Winsome (McCune Ranch), SP-18-006

Please accept the following revised comments from El Paso County Public Health (EPCPH) regarding the project referenced above:

SEPTIC SUITABILITY MAP
WINSOME SUBDIVISION
17480 MERIDIAN ROAD NORTH
EL PASO COUNTY, CO.
FOR: PROTERRA PROPERTIES, LLC

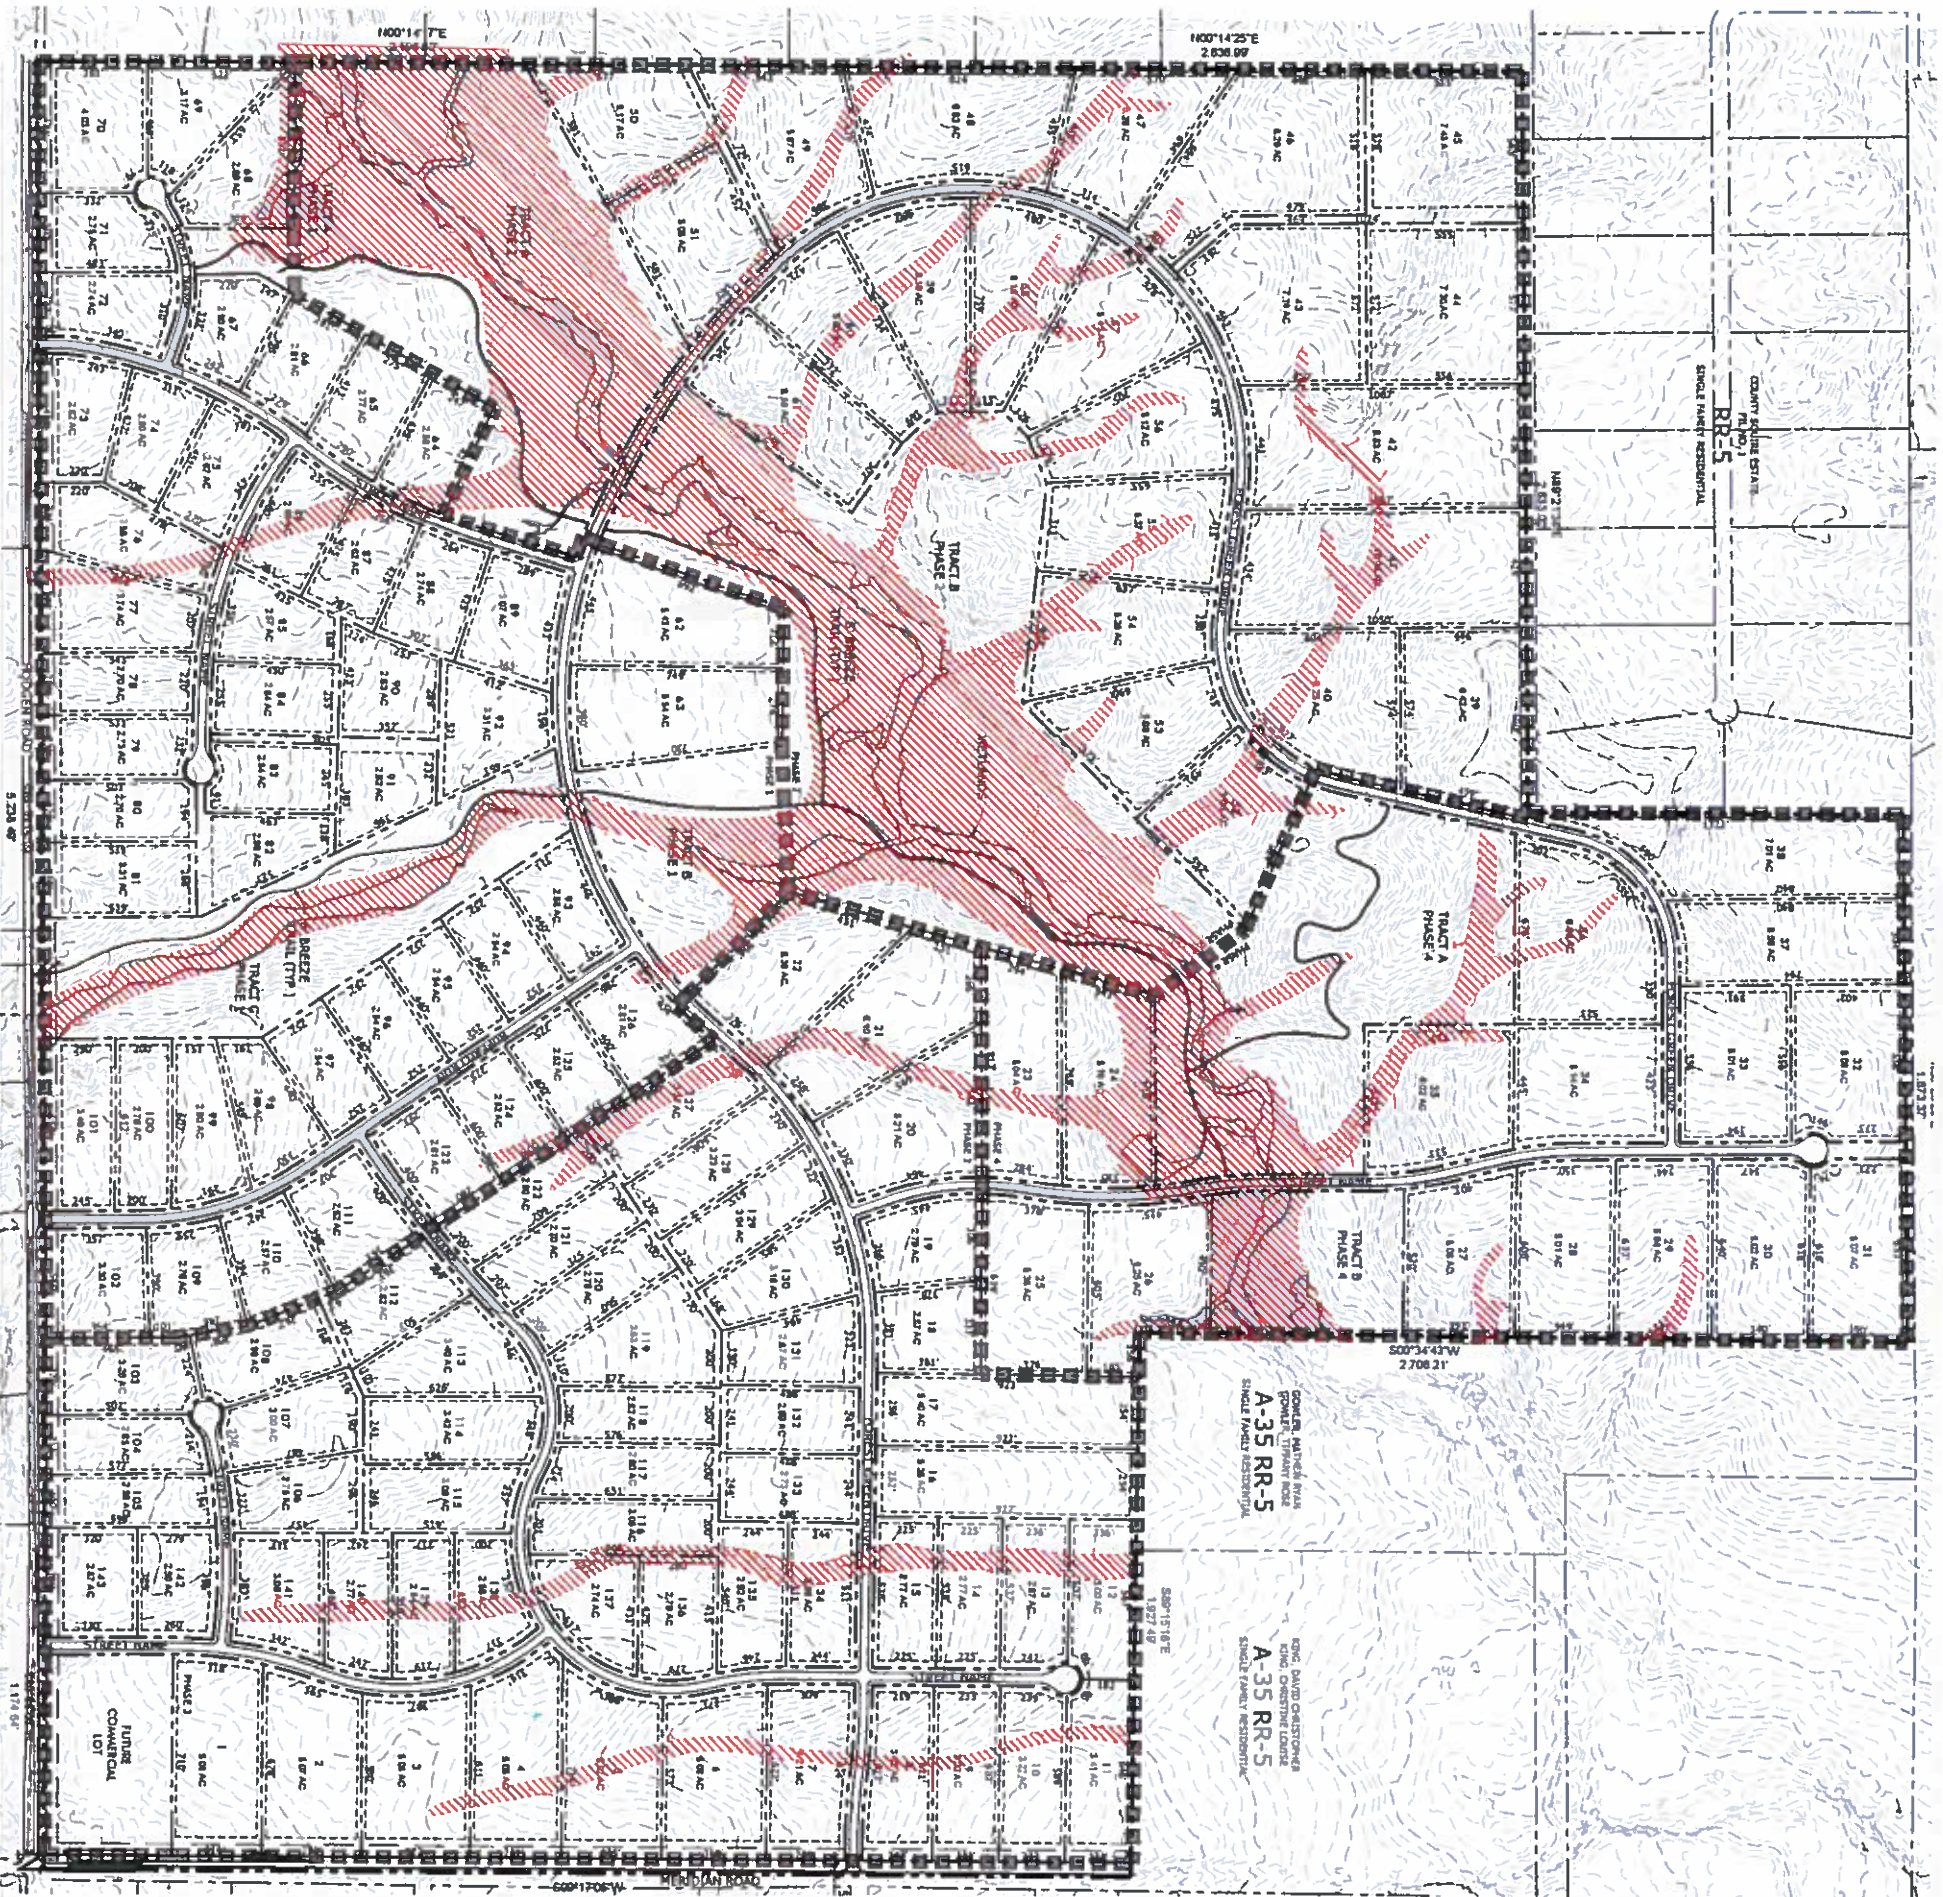
- A determination of the suitability of the subdivision for the preliminary plan use of OWTS's is not required; however, prior to the final plat the 14 remaining soil tests and an acceptable response to the issues with the lots identified in the comments below is required. EPCPH encourages the remaining 14 soil tests be conducted at least in a few of the lot areas listed below. Note: The soil test pits within the report did indicate that ground water was not encountered; however, the report did show the majority of the soil in the area is not suitable for conventional onsite wastewater treatment systems and will require professional engineer designs. The most common reason for concern are the lots identified on Figure 9 of the Entech Engineering, Inc.,

Preliminary Soil, Geology, Geologic Hazard and Wastewater Study dated 02Oct2018, (revised 11Jan2019) for Winsome Subdivision showing “areas that are not suitable for onsite wastewater treatment systems”.

- **Identified areas unsuitable for OWTS’s affect several lots. Depending on if these identified areas can be crossed by driveways and/or OWTS piping, this may place the house site and the OWTS in an area of the lot too small for locating the house, an OWTS, and a well, and still have the ability to meet all the internal and external minimum horizontal installation setbacks. NOTE: The lots listed below were identified only upon the review of the Figure 9 map, and there may not be as significant of an access issue to the entire lot as it appears. A discussion with Entech Engineering on 01May2019 indicated the low areas could be crossed by a driveway with the installation of a properly sized culvert. The lots identified are:**

Lots 5 – 11; Lot 21; Lots 23 – 24; Lot 41, Lot 44 (for an identified downslope creep area in mid-lot); Lot 49; Lot 52; Lots 54 - 55 (for unstable slope areas in mid-lot); Lots 57 – 61; Lot 86; Lot *127 (not Lot 128 as noted in the report narrative); Lots 134 – 135; Lots 138 - 141
